KITTITAS COUNTY

MEMORANDUM

TO: Community Development Services
FROM: Taylor Gustafson, Environmental/Transportation Planner
DATE: June 18, 2018
SUBJECT: Clark BL-18-00008

CLARK PROPERTY

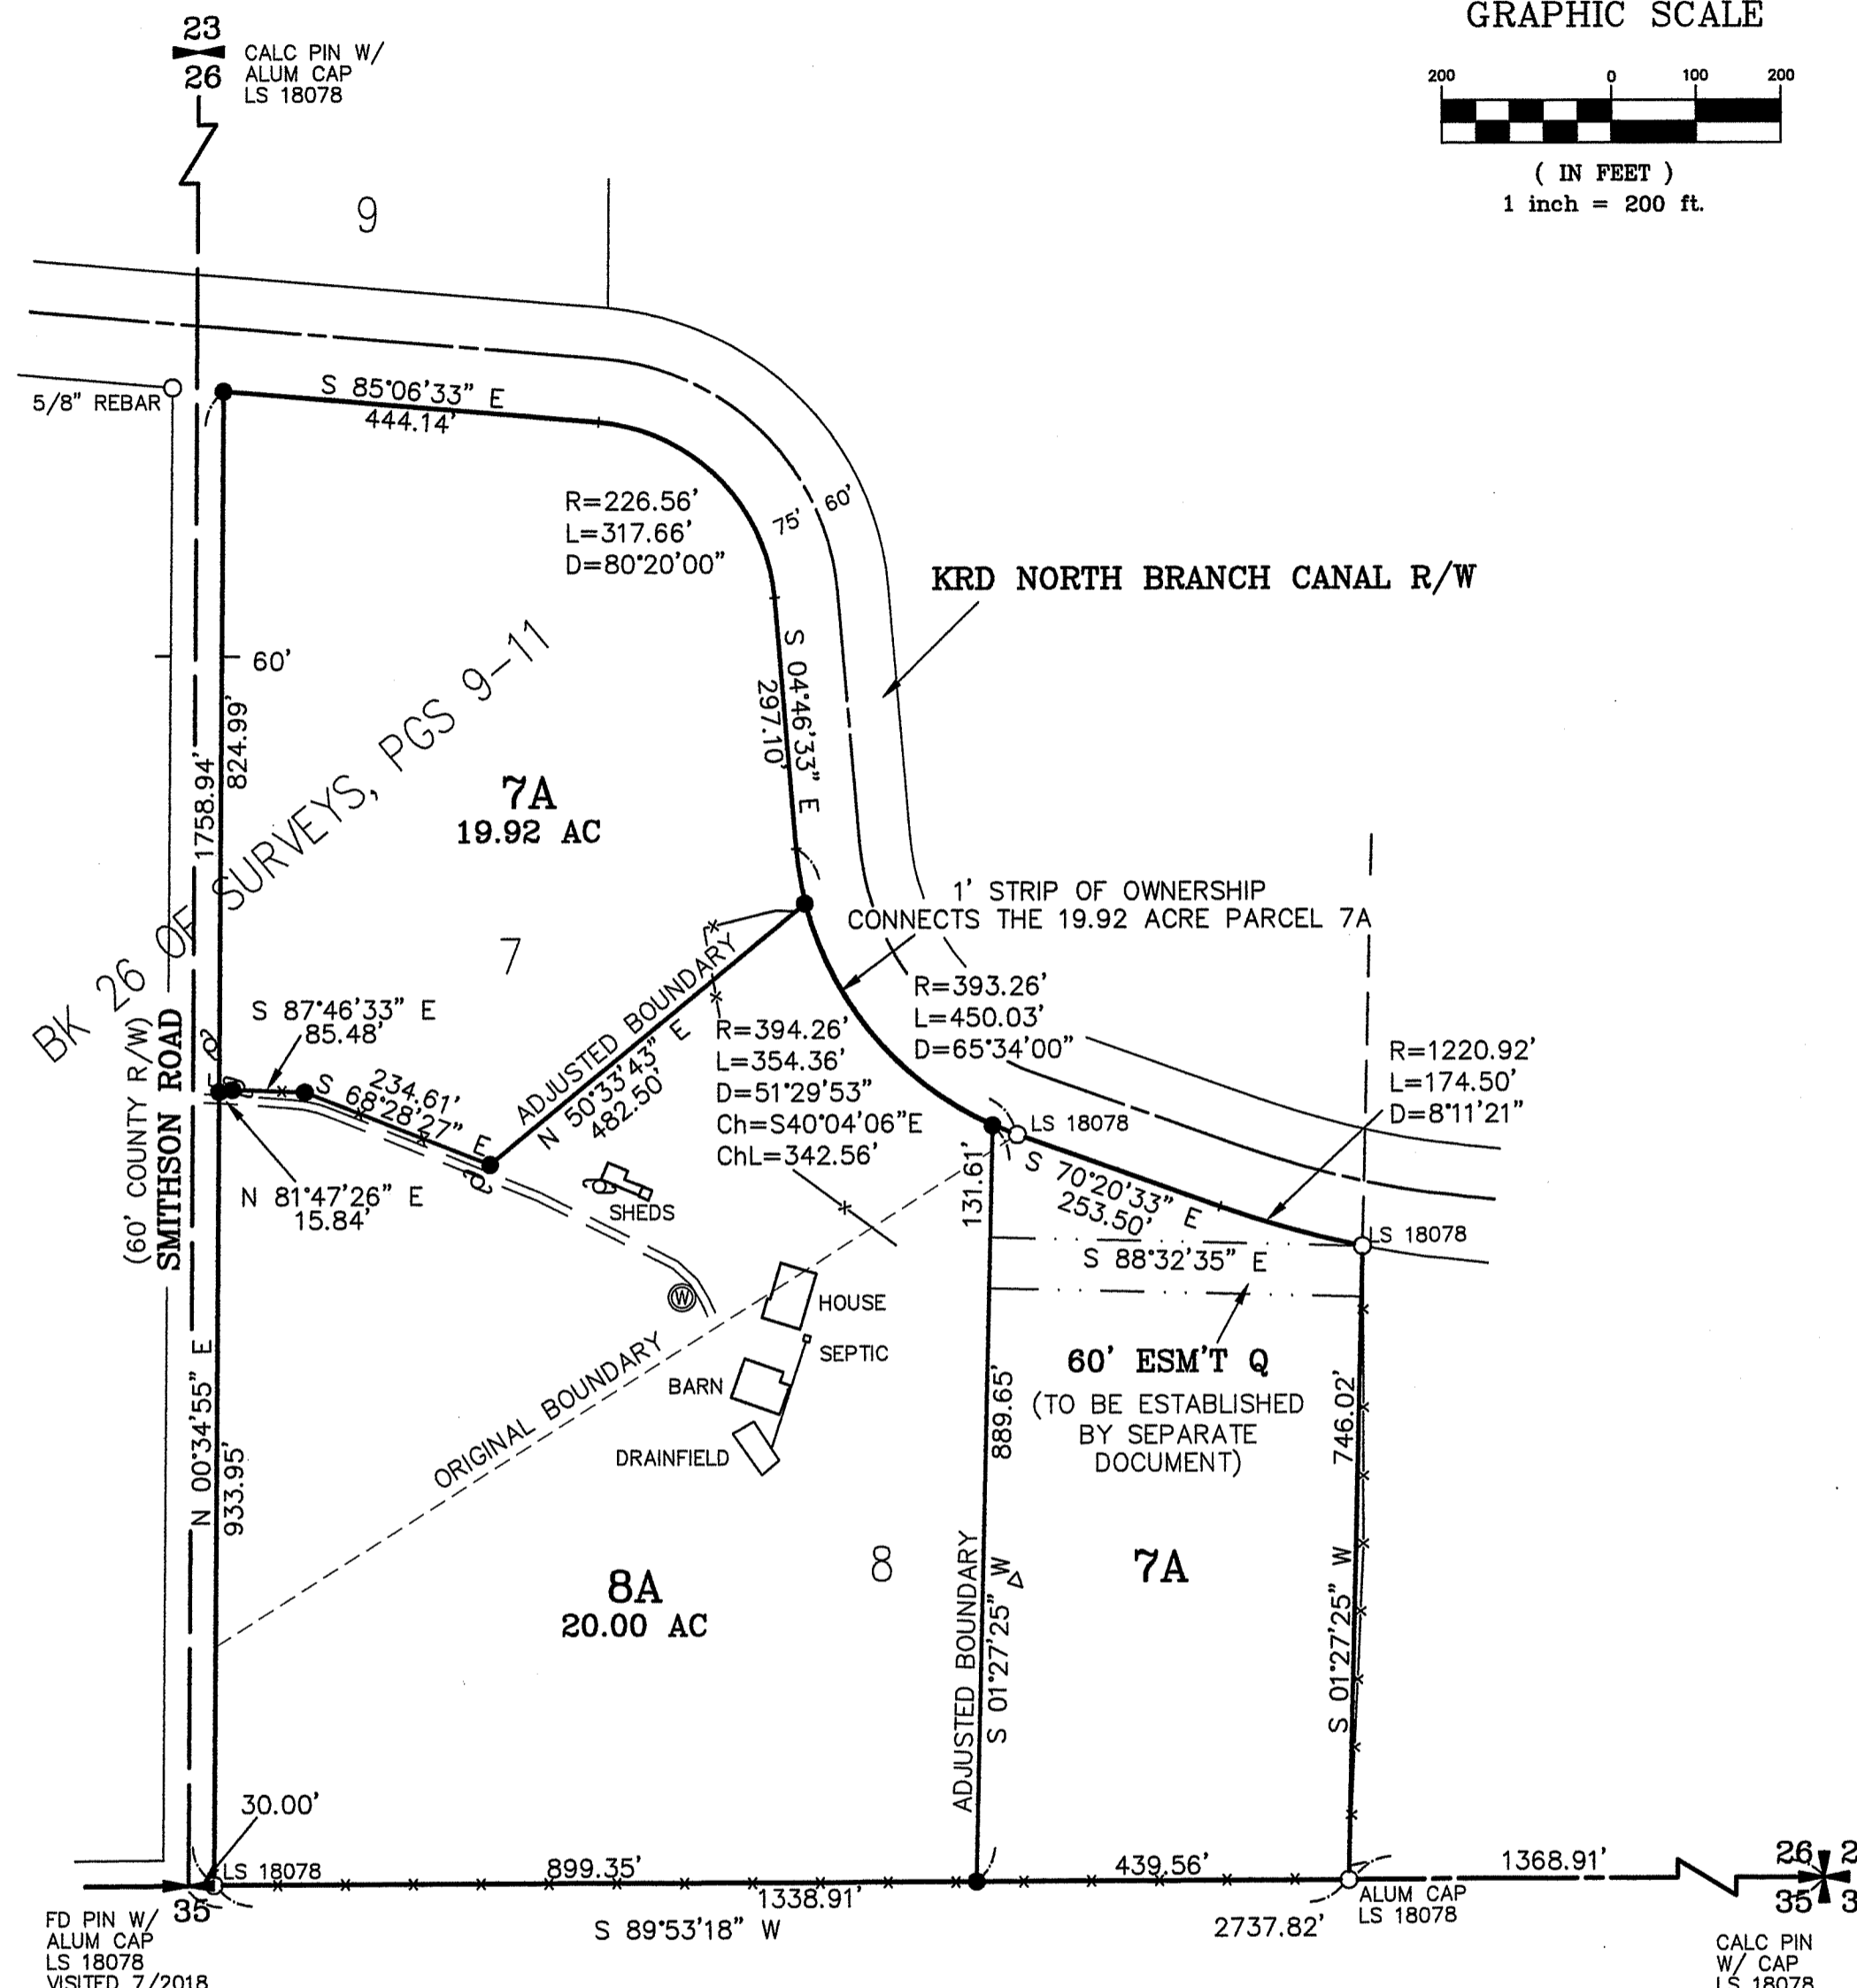
1. Provide sufficient access to the back half of lot 2. Proposed map shows only a 1' strip of land connecting the two sections.
2. Map shows County Right of Way as Church Road. Please relabel to Smithson Road.
